**Byers Gill Solar
EN010139**

3.3 DCO Schedule of Changes

Revision 6 – 8 January 2025

Drawing Title
Street Works, Public Rights of Way & Access Plans
Sheet 3 of 13
APFP Regulation 5(2)(k)

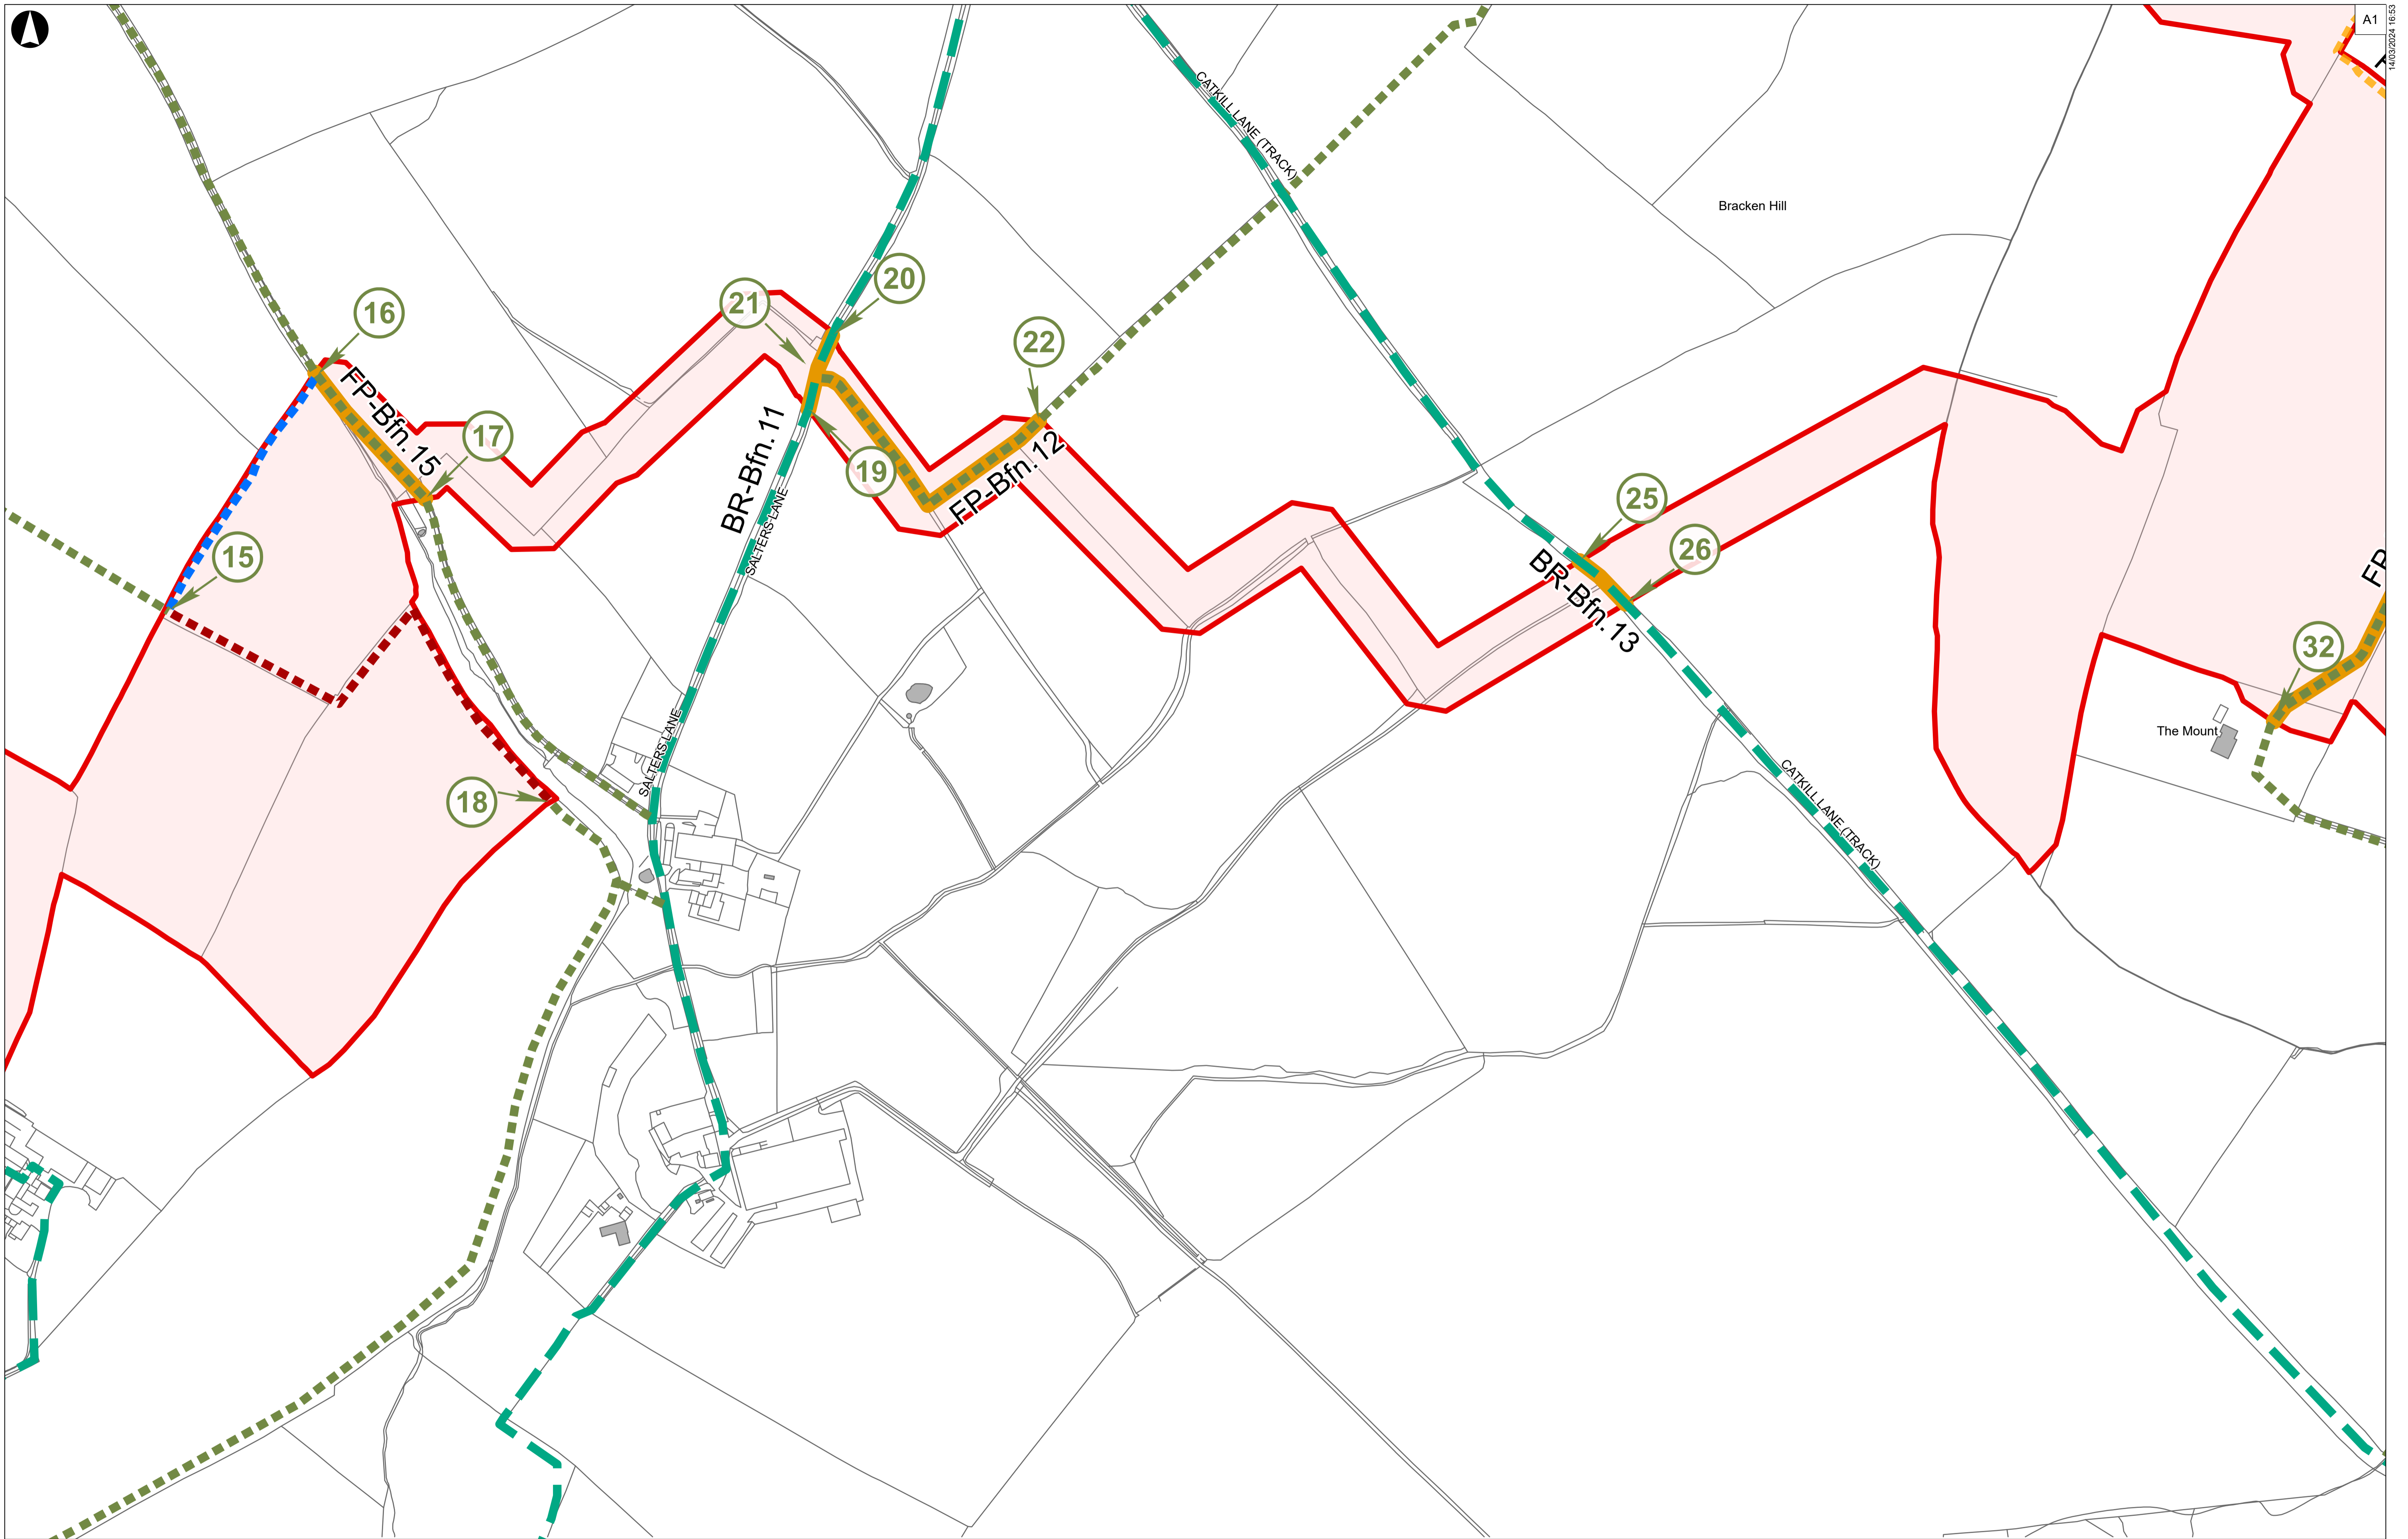
<p>For example, row 2 of the table has been amended as follows:</p> <table border="1" data-bbox="580 312 1267 643"> <tr> <td data-bbox="580 312 763 643"><i>Parish of Brafferton</i></td> <td data-bbox="763 312 913 643"><i>Unnamed Road</i></td> <td data-bbox="913 312 1267 643"><i>Cable works beneath the width of highway street comprising a length of 320m as shown between points marked A and B on sheet 3 of the street works, public rights of way and access plans.</i></td> </tr> </table>	<i>Parish of Brafferton</i>	<i>Unnamed Road</i>	<i>Cable works beneath the width of highway street comprising a length of 320m as shown between points marked A and B on sheet 3 of the street works, public rights of way and access plans.</i>				
<i>Parish of Brafferton</i>	<i>Unnamed Road</i>	<i>Cable works beneath the width of highway street comprising a length of 320m as shown between points marked A and B on sheet 3 of the street works, public rights of way and access plans.</i>

Drawing Title
Street Works, Public Rights of Way & Access Plans
 Sheet 9 of 13
APFP Regulation 5(2)(k)

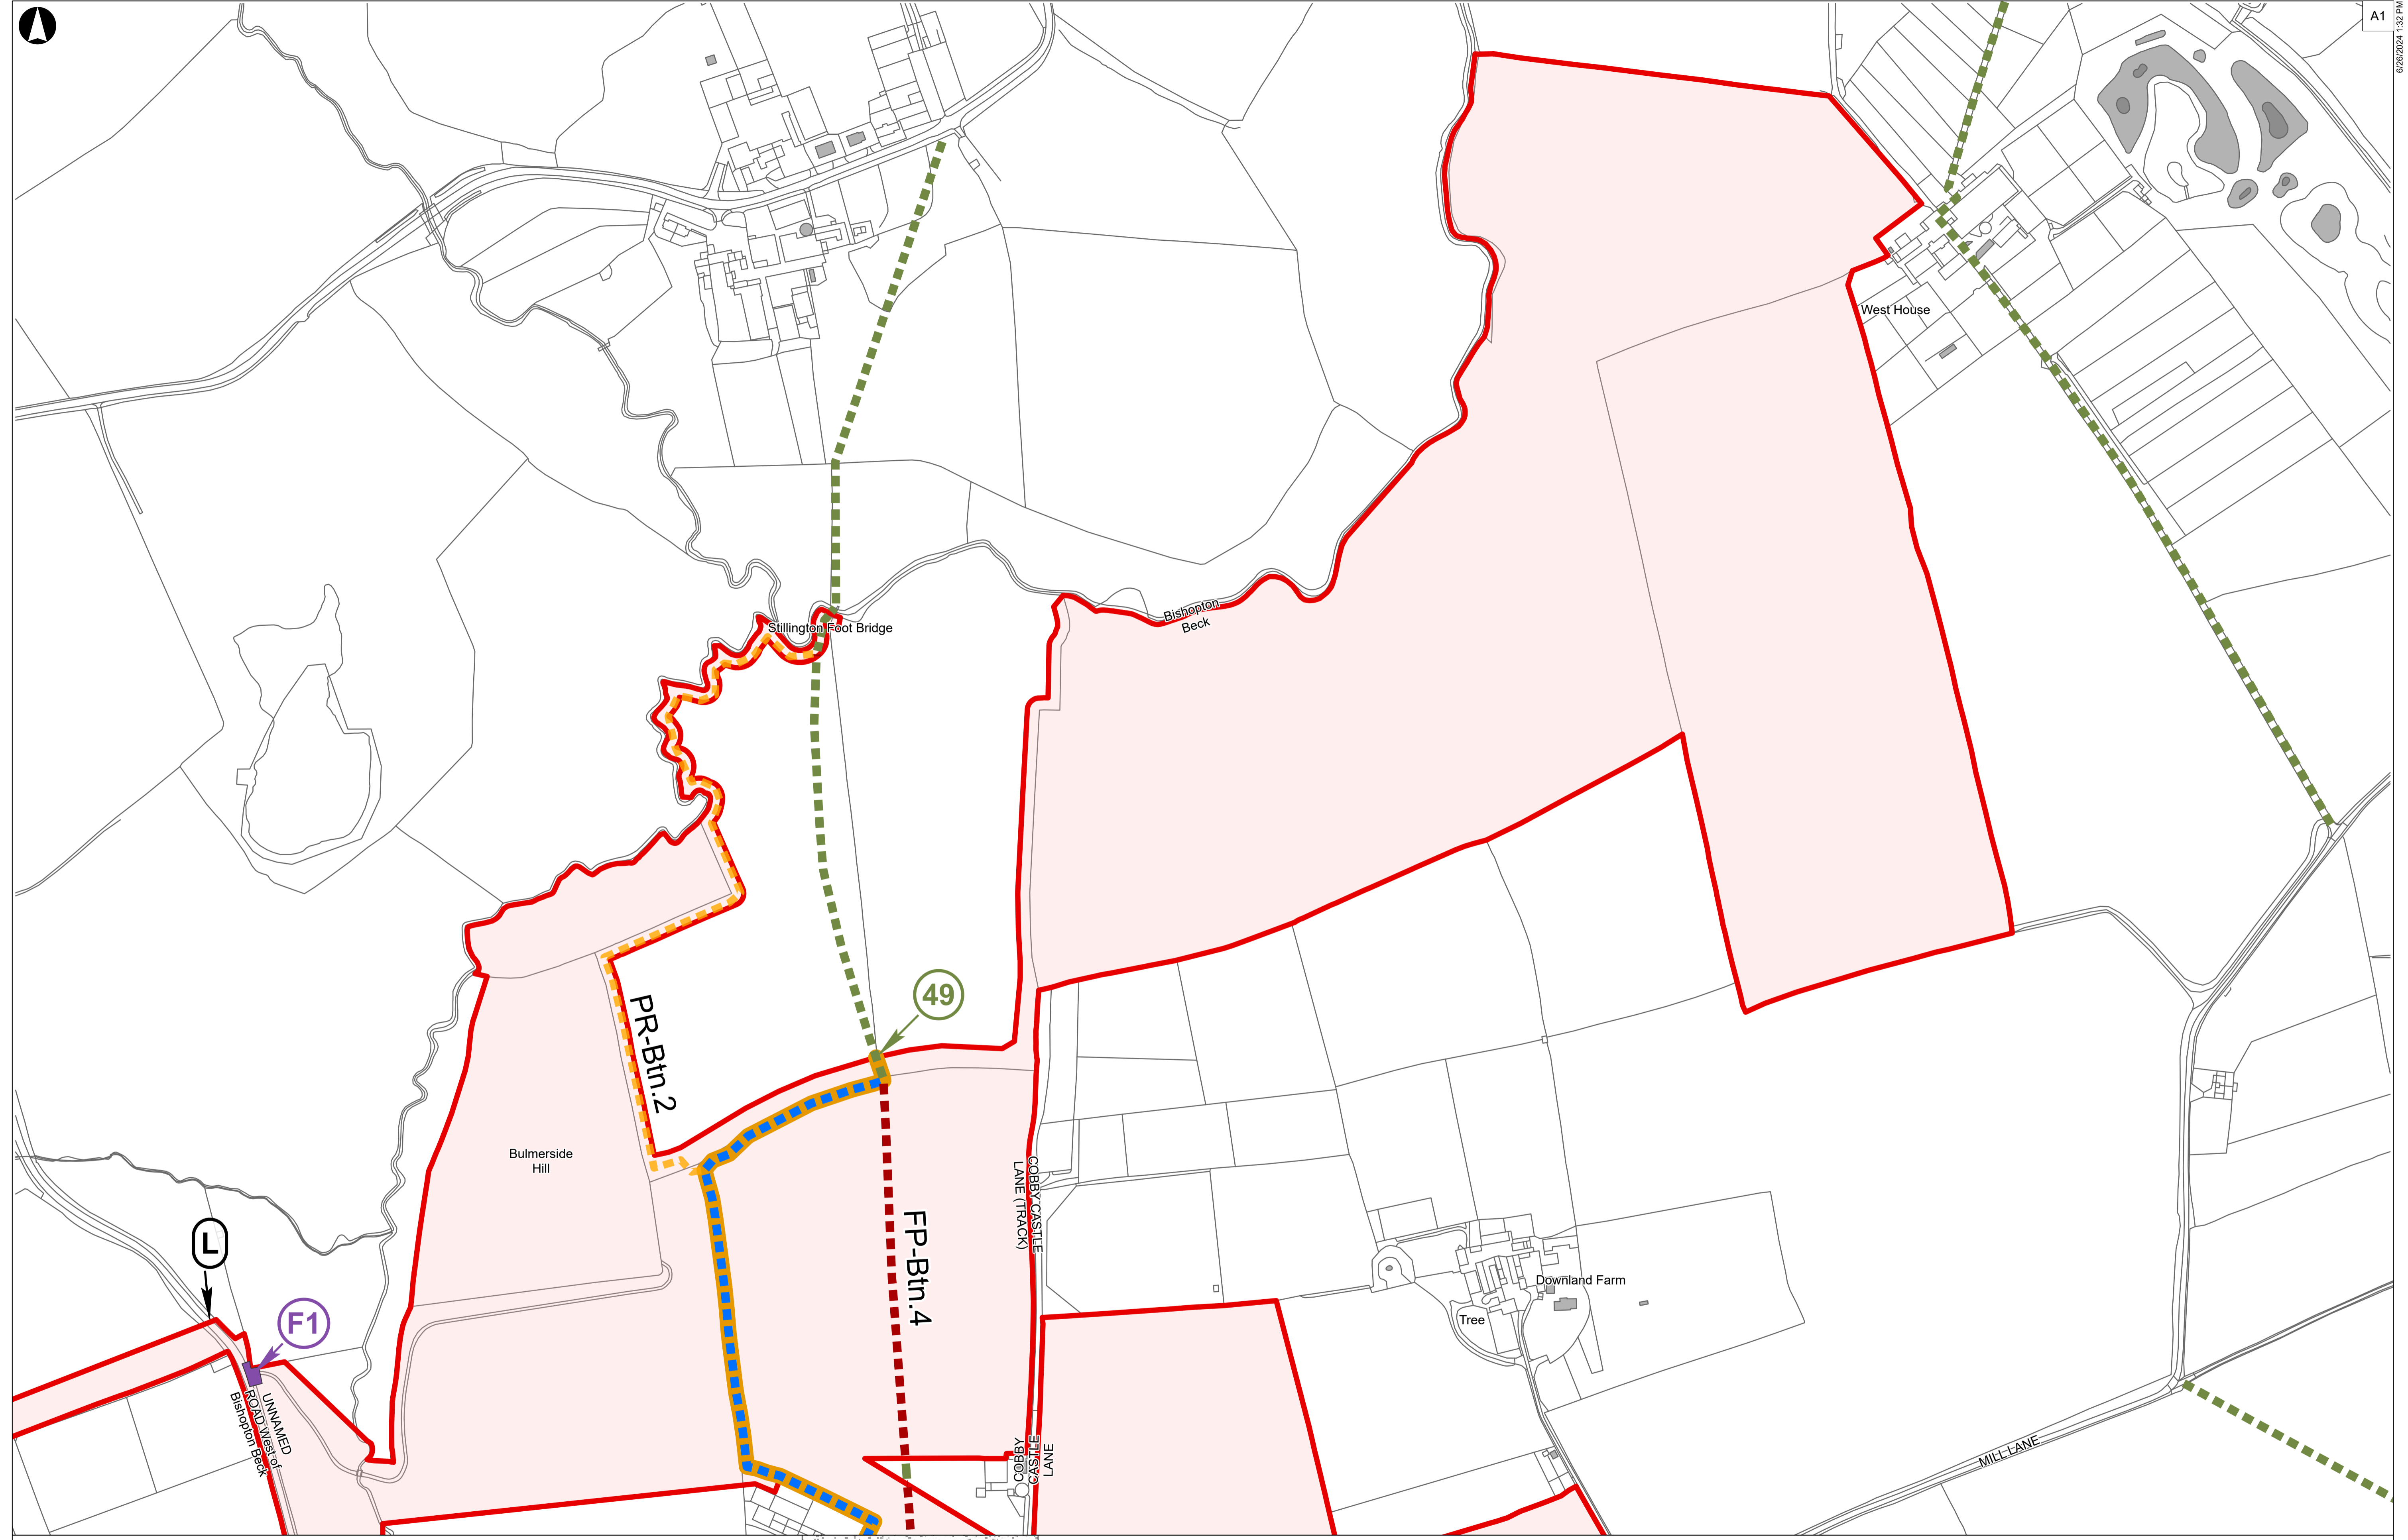
<p>Within the table of street works in Schedule 3, two rows have been added as follows:</p> <table border="1" data-bbox="580 802 1267 1310"> <tr> <td data-bbox="580 802 775 1054"><u><i>Parish of Bishopton</i></u></td> <td data-bbox="775 802 943 1054"><u><i>Folly Bank</i></u></td> <td data-bbox="943 802 1267 1054"><u><i>Cable works beneath the width of street as shown with reference CC5 on sheet 9 of the street works, public rights of way and access plans.</i></u></td> </tr> <tr> <td data-bbox="580 1054 775 1310"><u><i>Parish of Redmarshall</i></u></td> <td data-bbox="775 1054 943 1310"><u><i>Redmarshall Road, in the vicinity of Morington Bridge</i></u></td> <td data-bbox="943 1054 1267 1310"><u><i>Cable works beneath the width of street as shown with reference CC6 on sheet 11 of the street works, public rights of way and access plans.</i></u></td> </tr> </table>	<u><i>Parish of Bishopton</i></u>	<u><i>Folly Bank</i></u>	<u><i>Cable works beneath the width of street as shown with reference CC5 on sheet 9 of the street works, public rights of way and access plans.</i></u>	<u><i>Parish of Redmarshall</i></u>	<u><i>Redmarshall Road, in the vicinity of Morington Bridge</i></u>	<u><i>Cable works beneath the width of street as shown with reference CC6 on sheet 11 of the street works, public rights of way and access plans.</i></u>	<p>These two rows have been added to provide street works descriptions for two locations where the Applicant proposes to carry out cabling works across the width of a street for the purpose of delivering the off-road cable route. These descriptions are included as a correction to Revision 1 of the dDCO.</p> <p>Corresponding amendments have been made to the Street Works, Public Rights of Way and Access Plans to indicate these locations.</p>

<u><i>Parish of Bishopton</i></u>	<u><i>Folly Bank</i></u>	<u><i>Cable works beneath the width of street as shown with reference CC5 on sheet 9 of the street works, public rights of way and access plans.</i></u>						
<u><i>Parish of Redmarshall</i></u>	<u><i>Redmarshall Road, in the vicinity of Morington Bridge</i></u>	<u><i>Cable works beneath the width of street as shown with reference CC6 on sheet 11 of the street works, public rights of way and access plans.</i></u>
